Rezoning Transportation Analysis

Petition Number: 2023-007

Date	Description
05-23-2023	First Review (JP)
6-21-2023	Second Review (DR)

SHEET TITLE
REZONING PLAN: PETITION # 2023-007

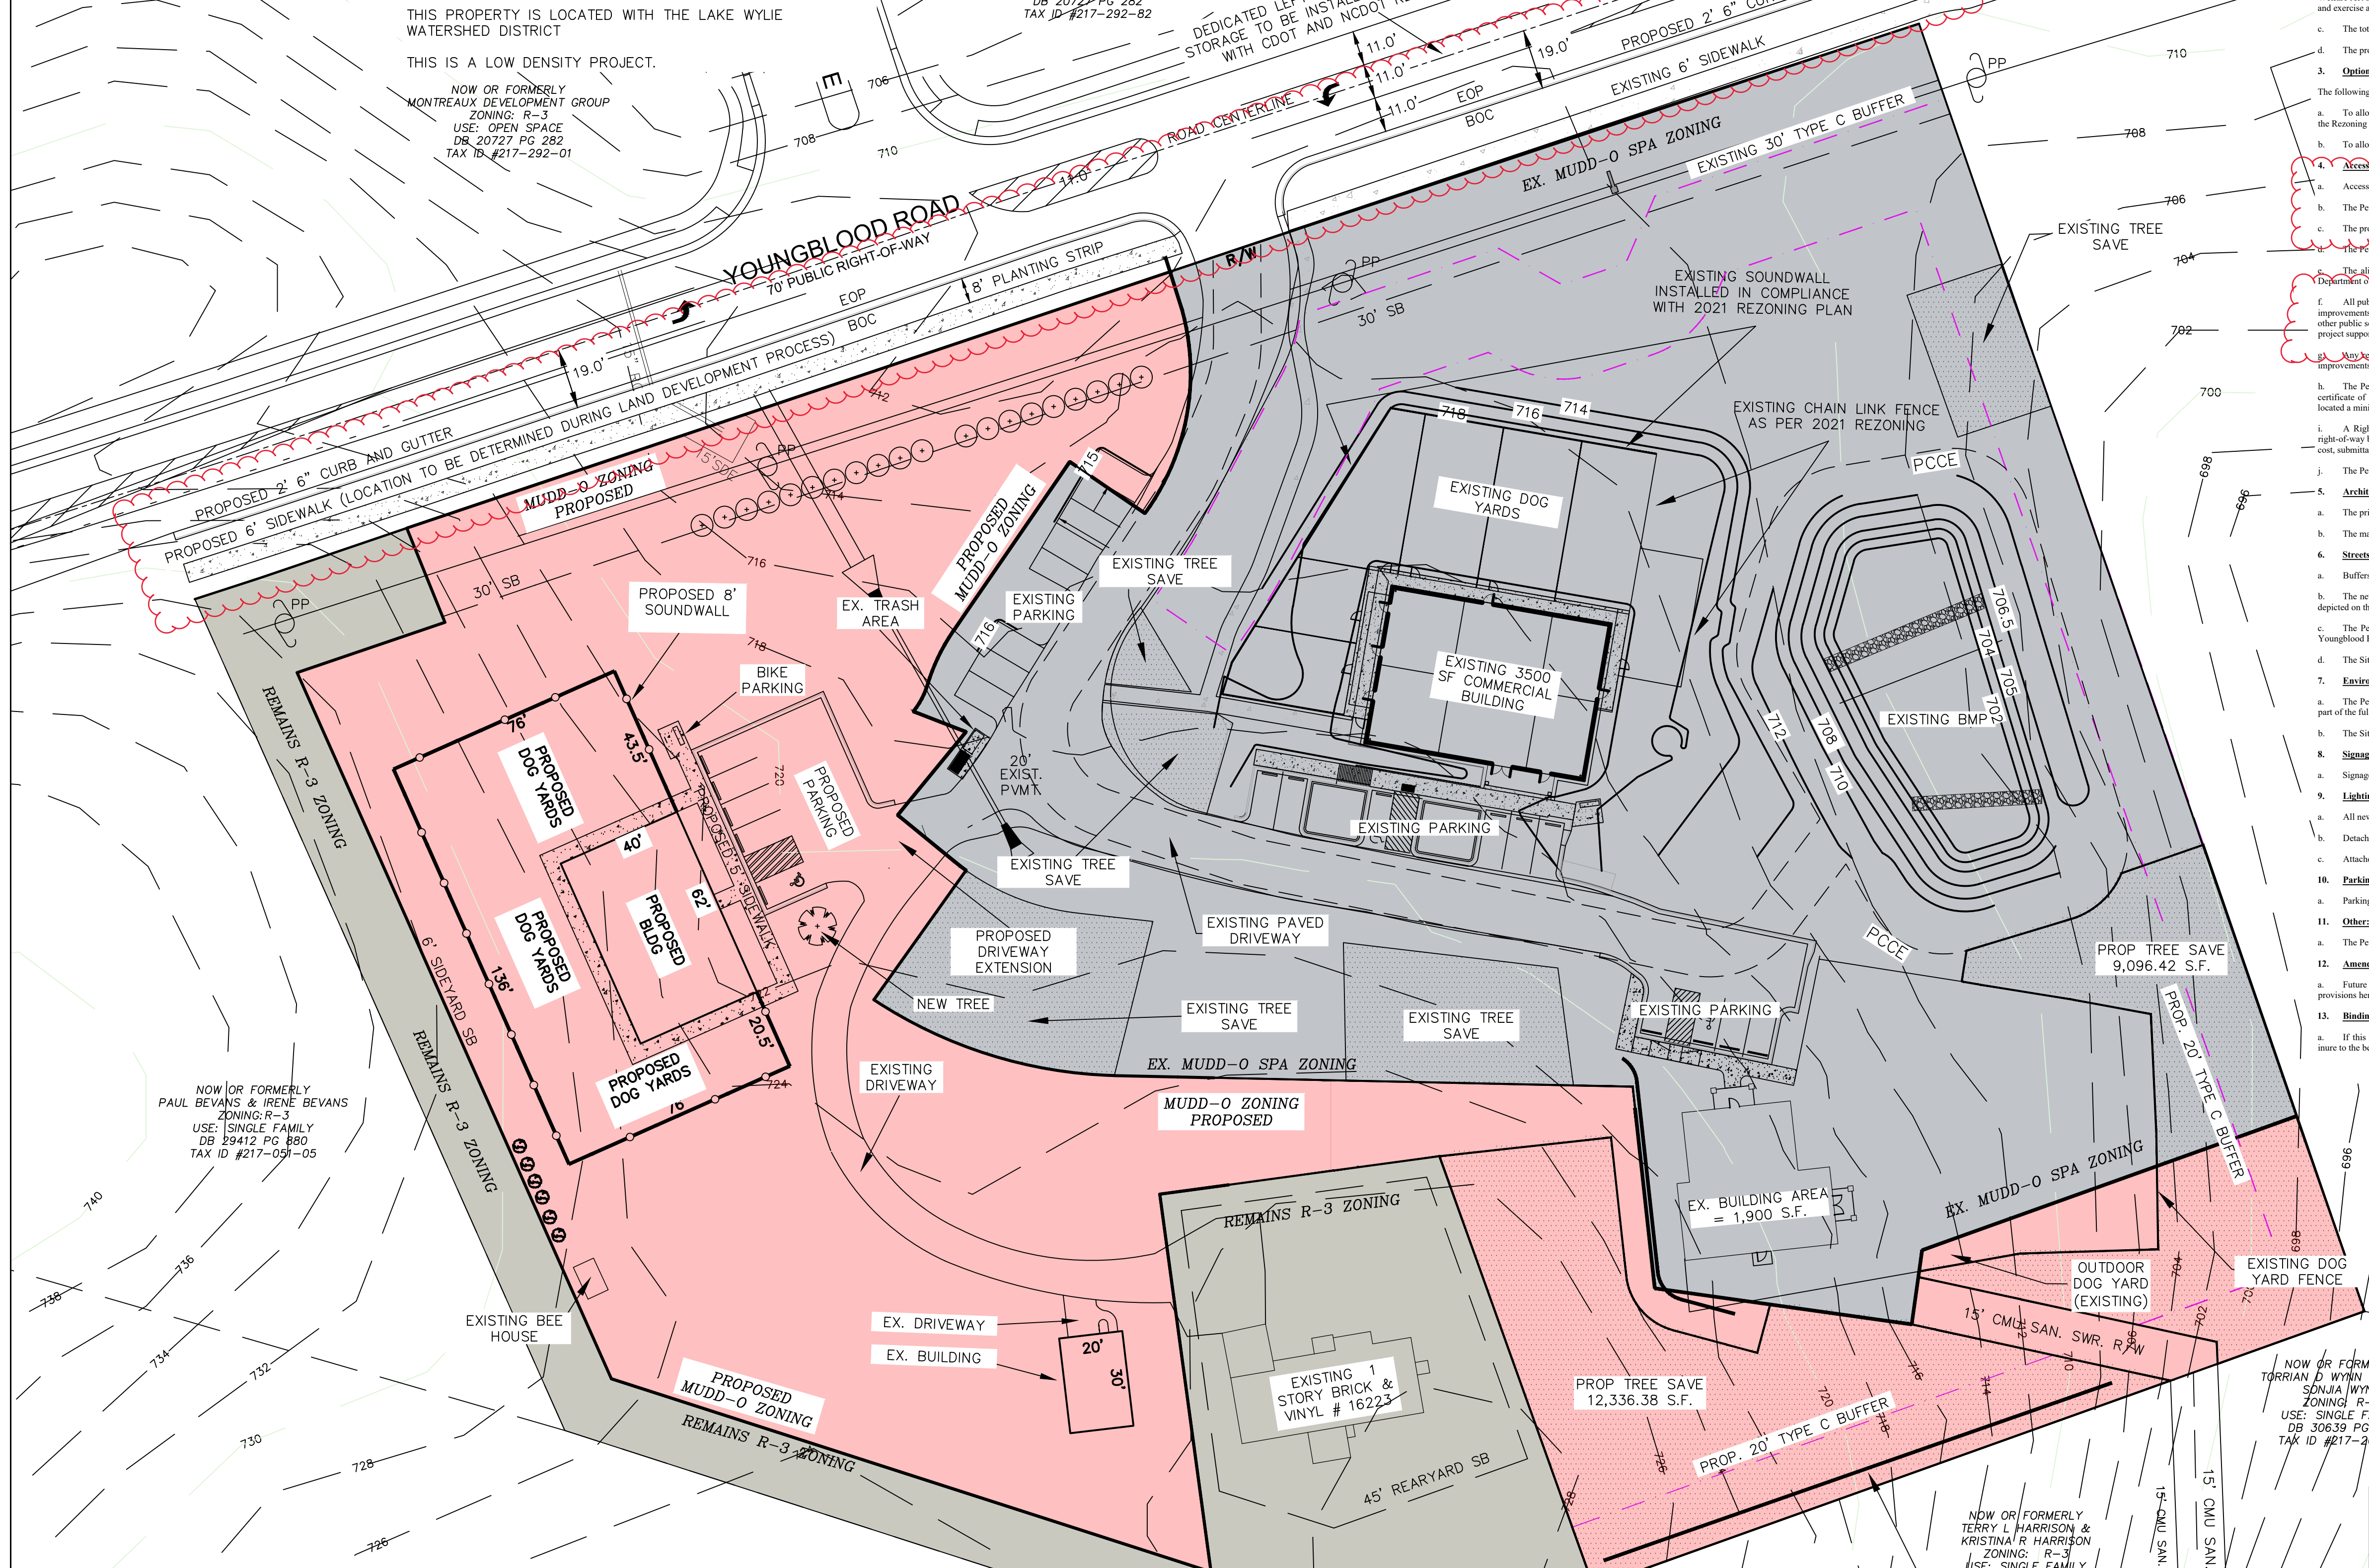
- Youngblood Road:** Location of curb and gutter to be moved to 19 feet from roadway centerline to accommodate the Charlotte Streets Map with a roadway typical section of a 2+ avenue with an 8-foot planting strip and a 12-foot multi-use path.

Label and dimension the curb and gutter from the centerline for each road on the site plan.

Clarifying comment 6.21.2023: Label and dimension back of curb from the roadway centerline of Youngblood Road.

6. Revise site plan and conditional note(s) to commit to installing a left turn lane on Youngblood Road with 100 feet of storage.

Clarifying comment 6.21.2023: Revise conditional note to ensure restripe is spelled correctly.

b. The Petitioner will **re-strip** Youngblood Rd. as generally depicted on the Rezoning Plan to create a westbound left turn lane with 100 feet of storage and appropriate taper from Youngblood Rd. into the Site.

9. Add conditional note specifying "All public roadway improvements will be subject to the standards and criteria of CDOT and NCDOT, as applicable, to the roadway improvements within their respective road system authority. It is understood that such improvements may be undertaken by the Petitioner on its own or in conjunction with other development or roadway projects taking place within the broad southwestern Mecklenburg area, by way of a private/public partnership effort or other public sector project support."

Clarifying comment 6.21.2023: Add conditional note.

10. Revise site plan and conditional note(s) to construct 8-foot planting strips and 12-foot multi-use path on Youngblood Road. The site plan shall label and dimension both items from the back of curb and gutter. Add conditional note the entire facility must be outside of the right of way and within a public access easement. Add conditional note committing to construction and maintenance of the 12-foot multi-use paths on Youngblood Road.
